PROJECT NAME: LANDS OF MARY FELDMAN

**CITY OF ALBUQUERQUE
PLANNING DEPARTMENT
January 21, 2015
DRB Comments**

PROJECT # 1007420

RE: Tracts 87-C-1A & 87-C-3A, MRGCD Map No. 35

DECEMBER 2014

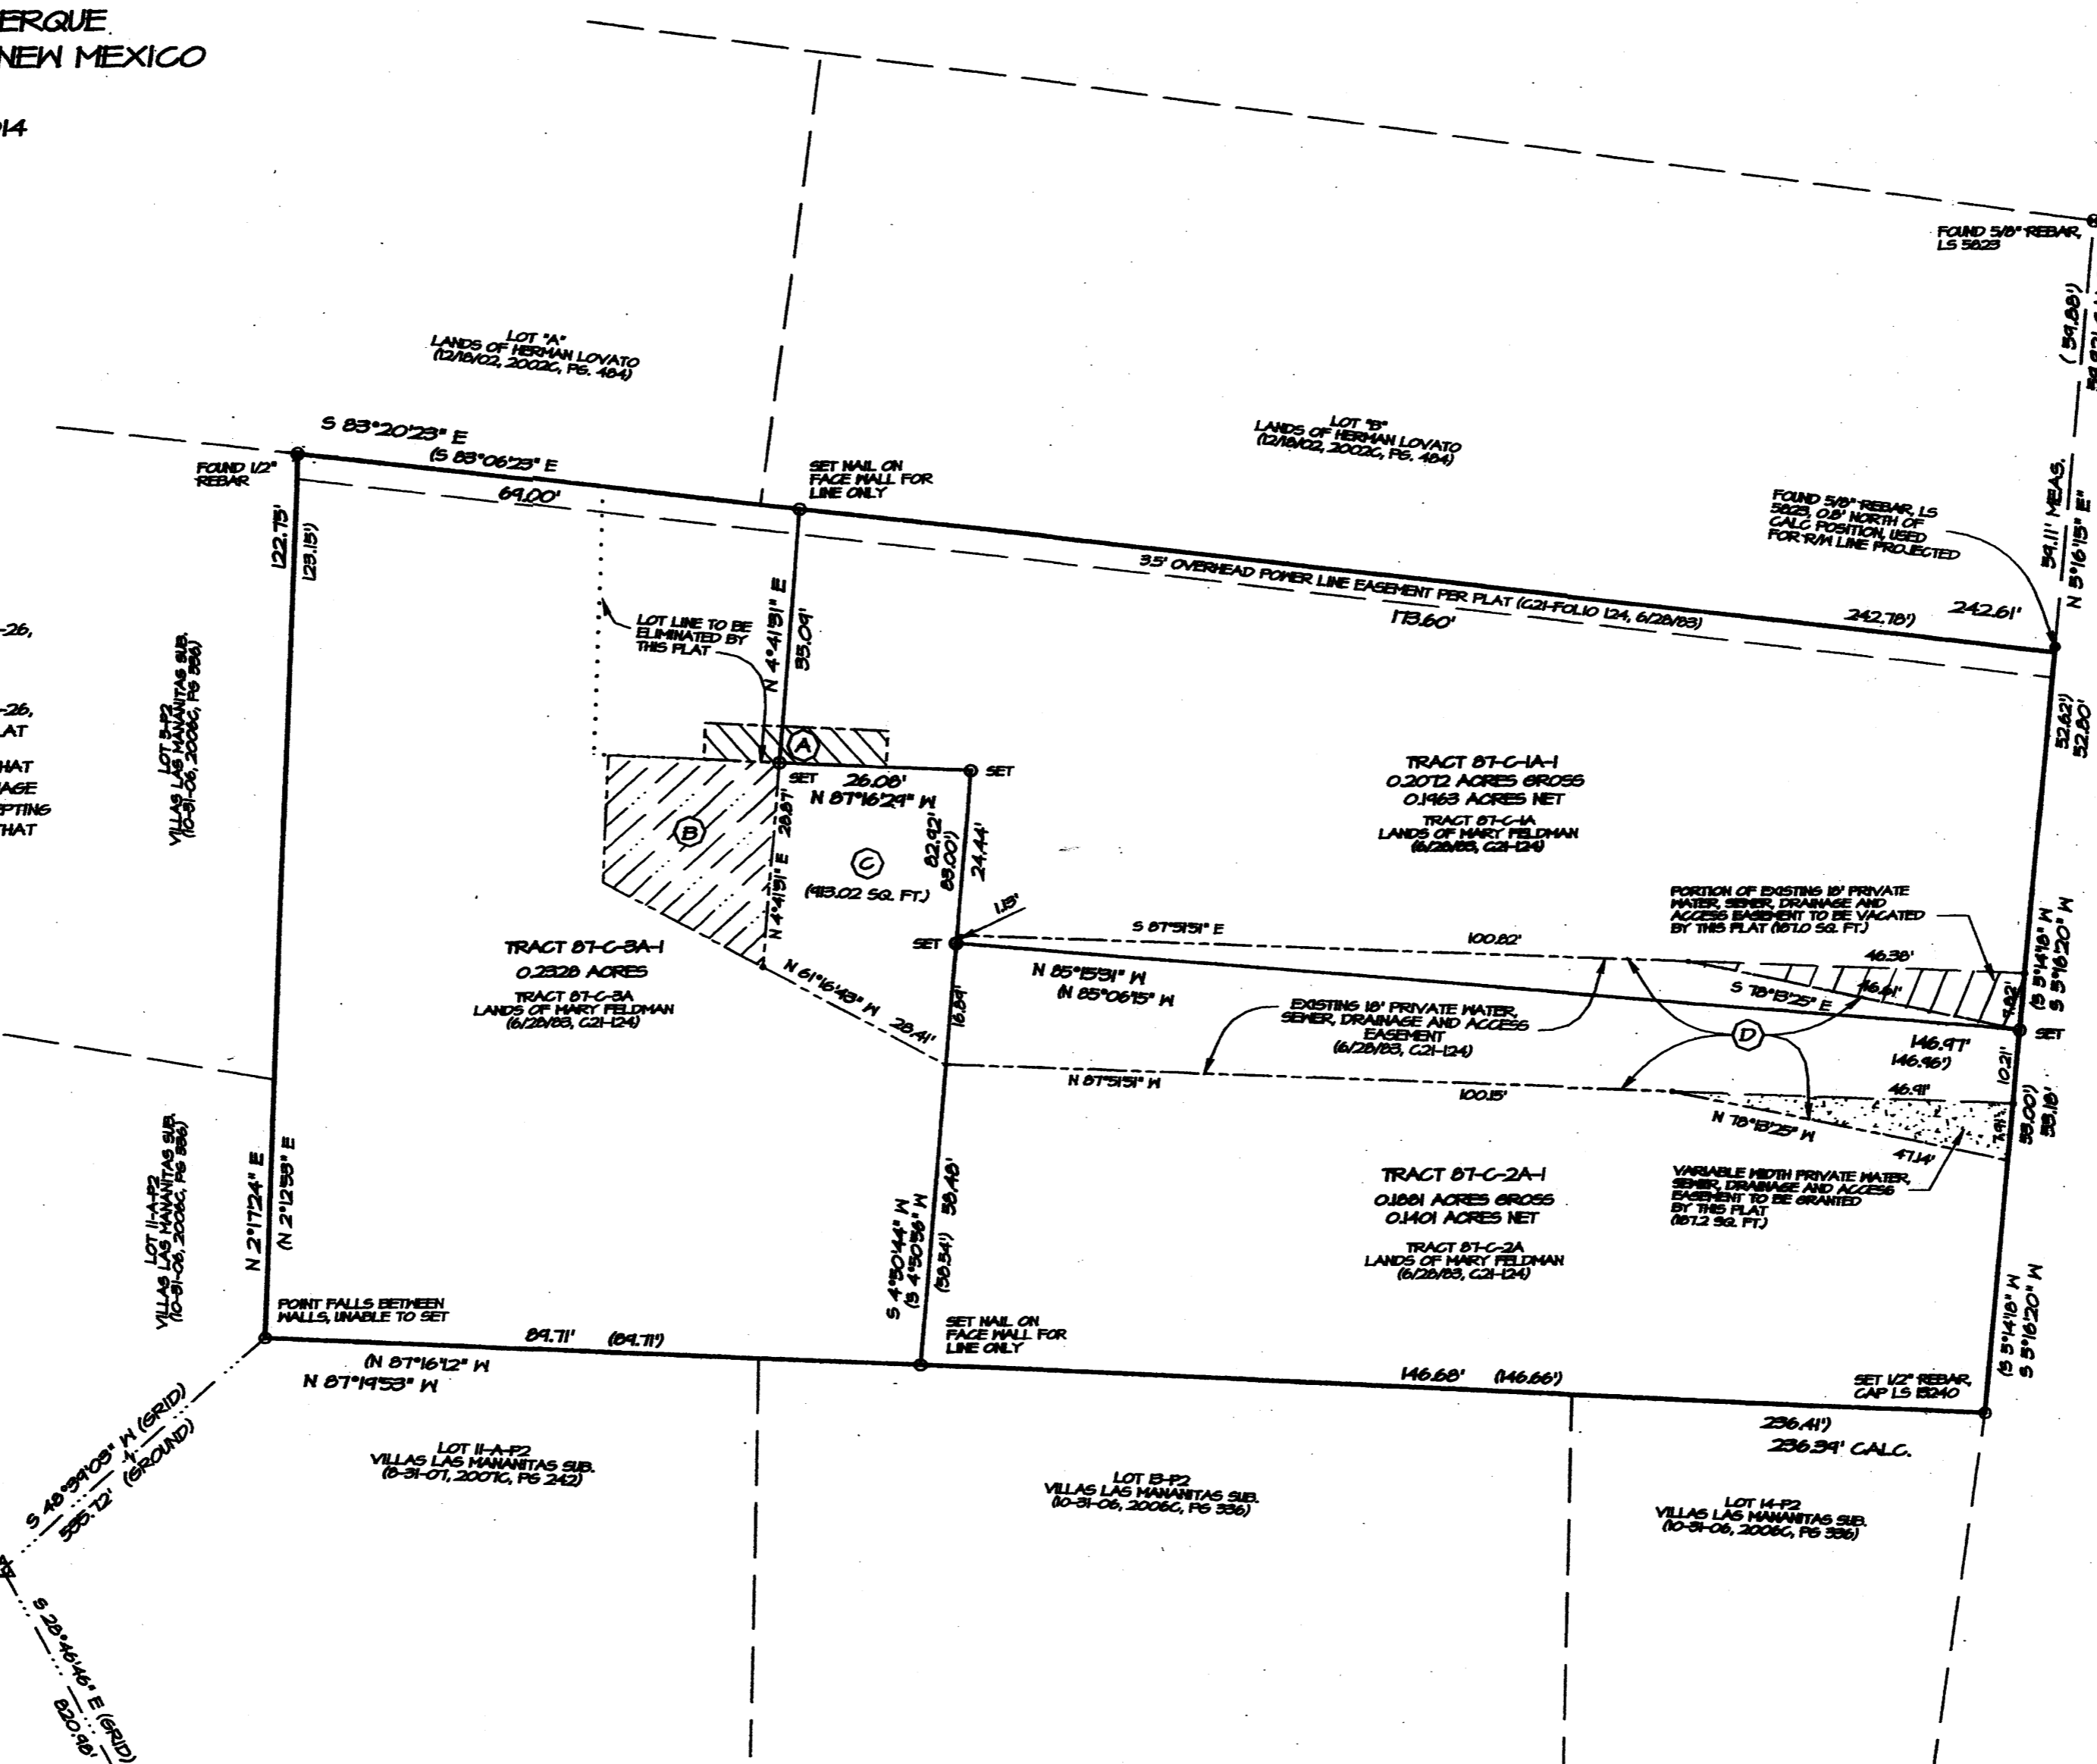
A request for Subdivision Design Variance must be formally applied for on Form V Item (DRB25) and an application number assigned; without a supporting dimensioned exhibit, the submitted narrative suggests a wider easement is possible (and it has been previously noted that there is a 24 foot curb cut on Meadow View Drive).

JUNE 2014

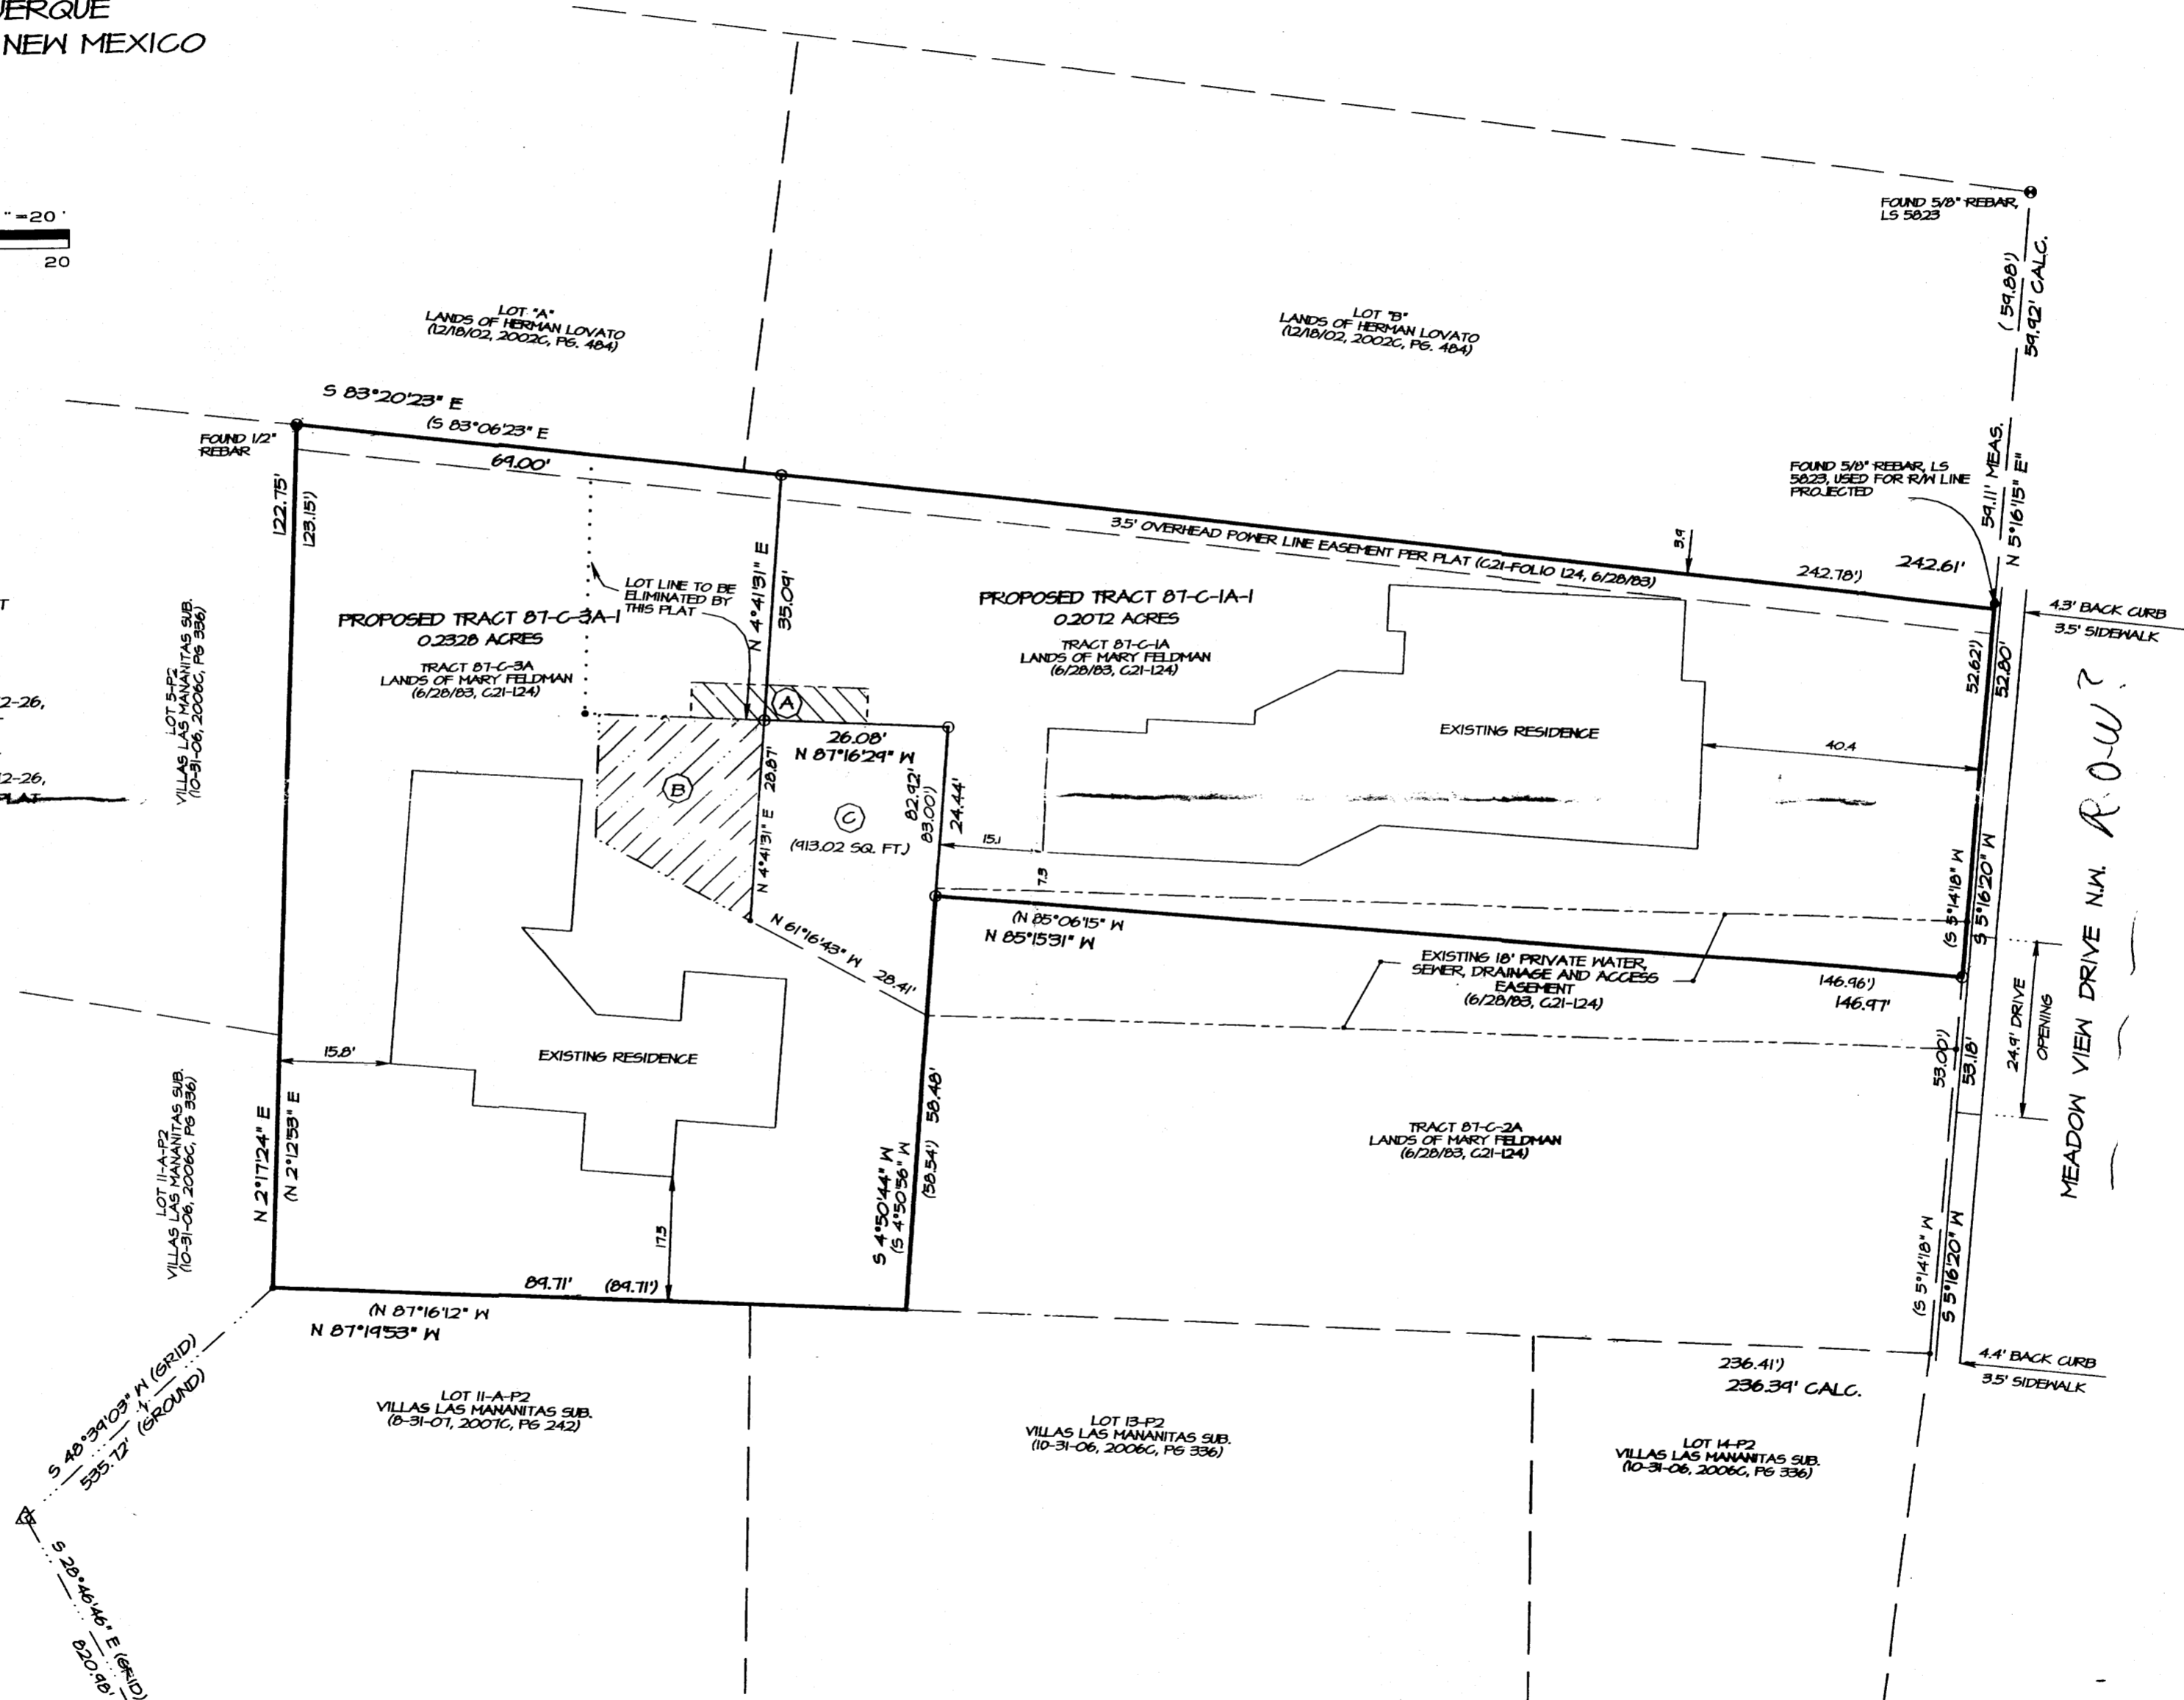
Vacation of private easements would require a vacation application (Form V) concurrent with Preliminary/ Final Plat application. Current standards for a private access serving 3 lots is minimum 22 ft; additional easement width will be needed. Please use an unbroken line type for the eastern boundary of Easement area "B." It appears from aerial photo that Easement "A" is defined by a fence; the east 'half' of this easement should be retained or the fence should be relocated.
